TOWN AND COUNTRY PLANNING ACT 1990 FULL

Reference: H08-0145-26 **Date of Decision:** 7th July 2026
Applicant: Mr & Mrs A Wilde
57-59 Salem Street
Gosberton
Spalding
Lincolnshire
PE11 4NQ
Location: 57 - 59 Salem Street Gosberton Spalding
Description: Replacement of entire roofing slates along with new guttering

DRAWING TITLE
Proposed Details

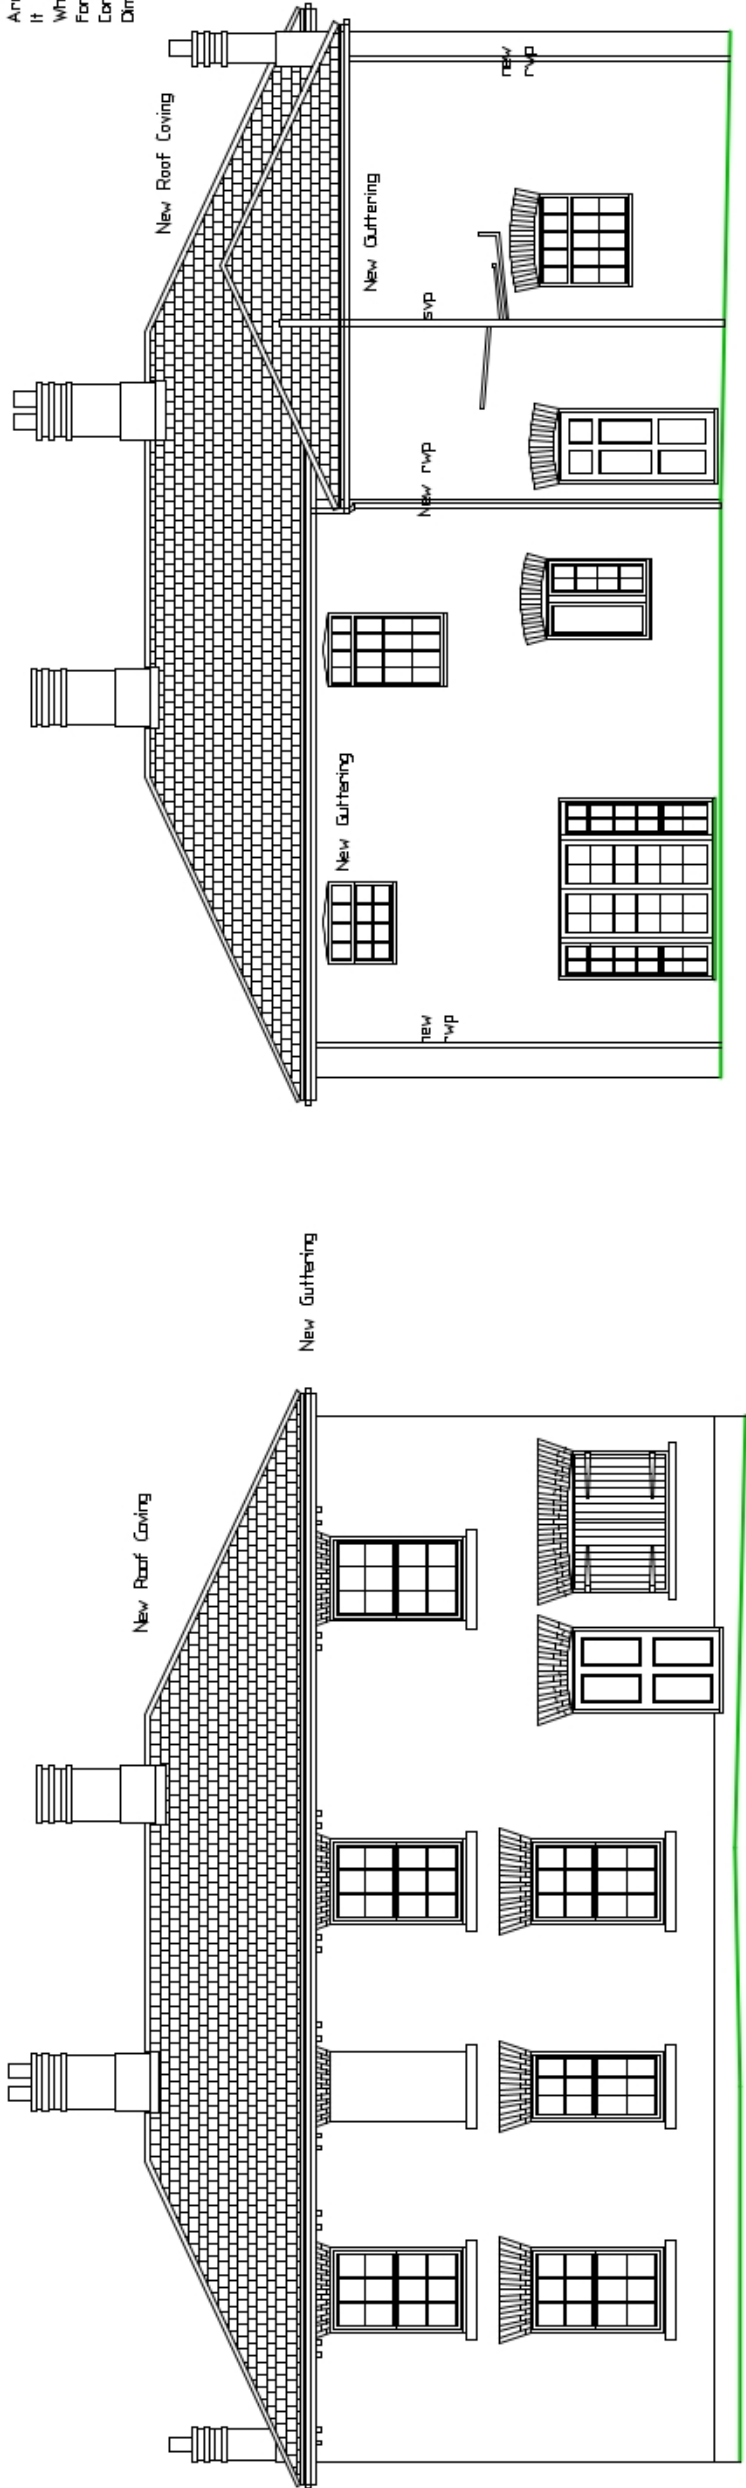
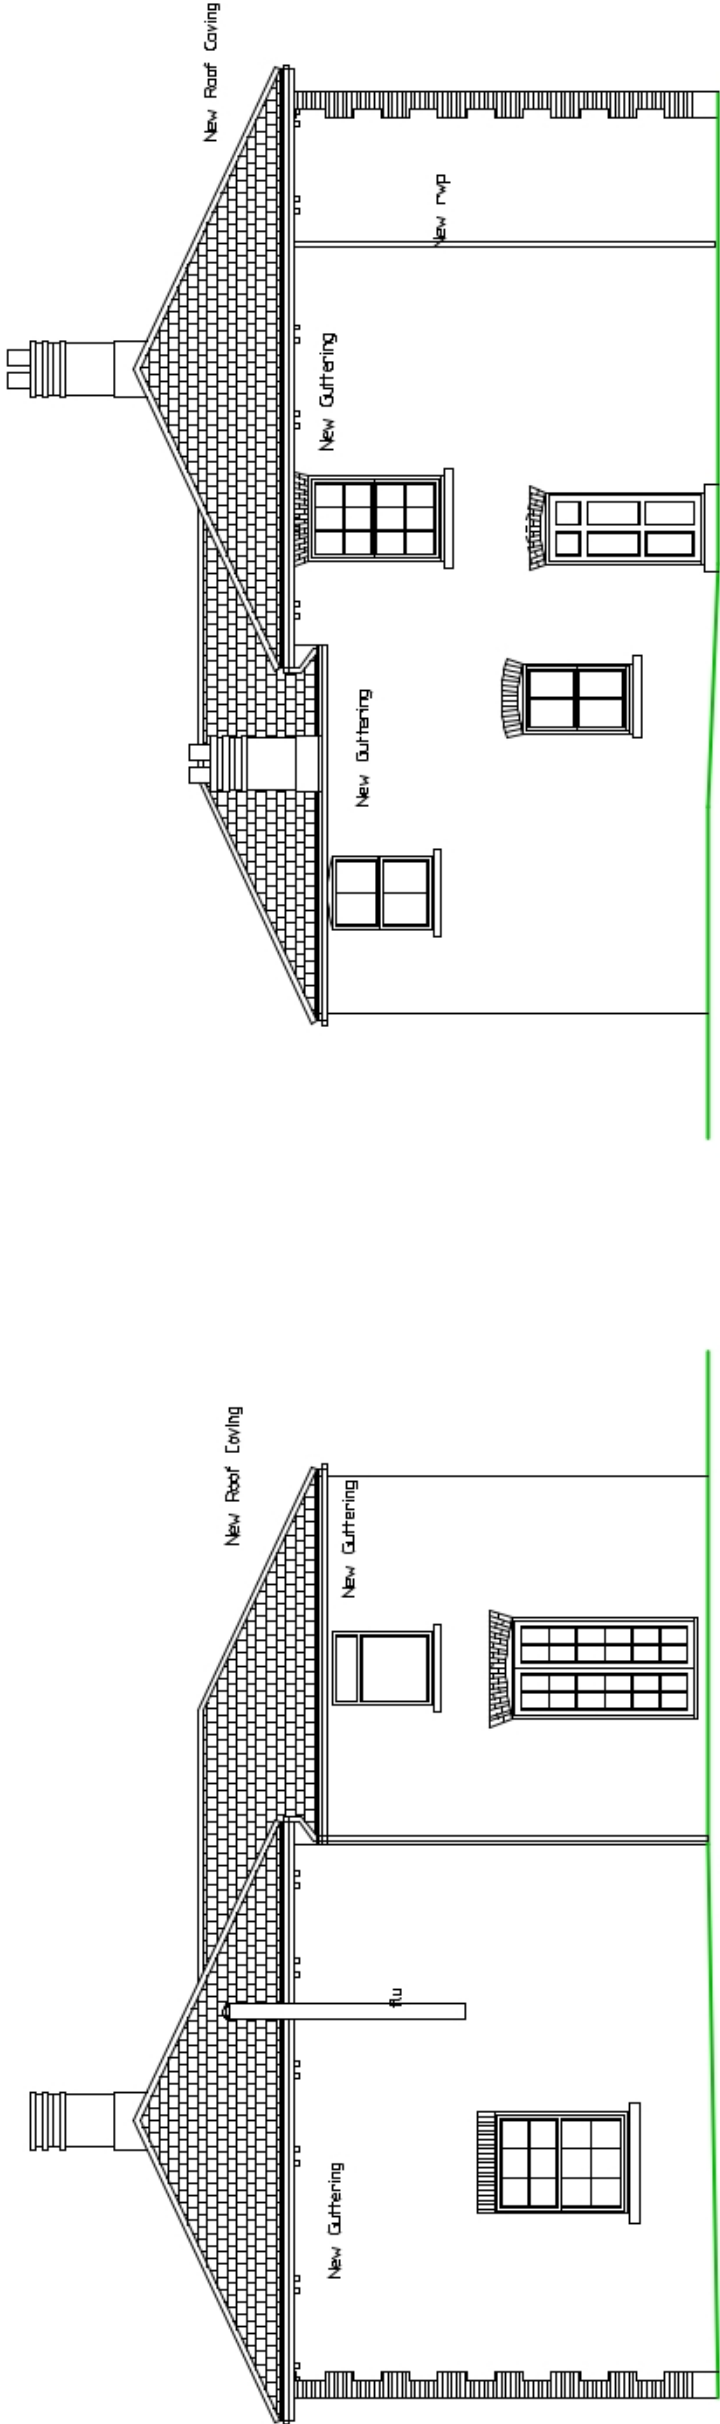
- 1 The proposal site is classified within the Historic Environment Record as a non-designated heritage asset and is within Gosberton Conservation Area.

The proposal would see the loss of orthodox, vernacular materials, and the introduction of inappropriate non-vernacular materials to a non-designated heritage asset in the Conservation Area. As a result, the proposal would be detrimental to the character and appearance of the host property and the wider Conservation Area. Accordingly, less than substantial harm has been identified, in line with Paragraphs 215, 216 and 220 of the National Planning Policy Framework, 2024.

In any event, Policy 29 of the South East Lincolnshire Local Plan, 2019 is clear that all proposals should preserve or enhance the historic environment. As the proposal would neither preserve, as traditional material would be lost, nor enhance, as the proposal is judged to degrade the appearance of the asset/ area, the proposal would be contrary to Policy 29 of the South East Lincolnshire Local Plan, 2019.
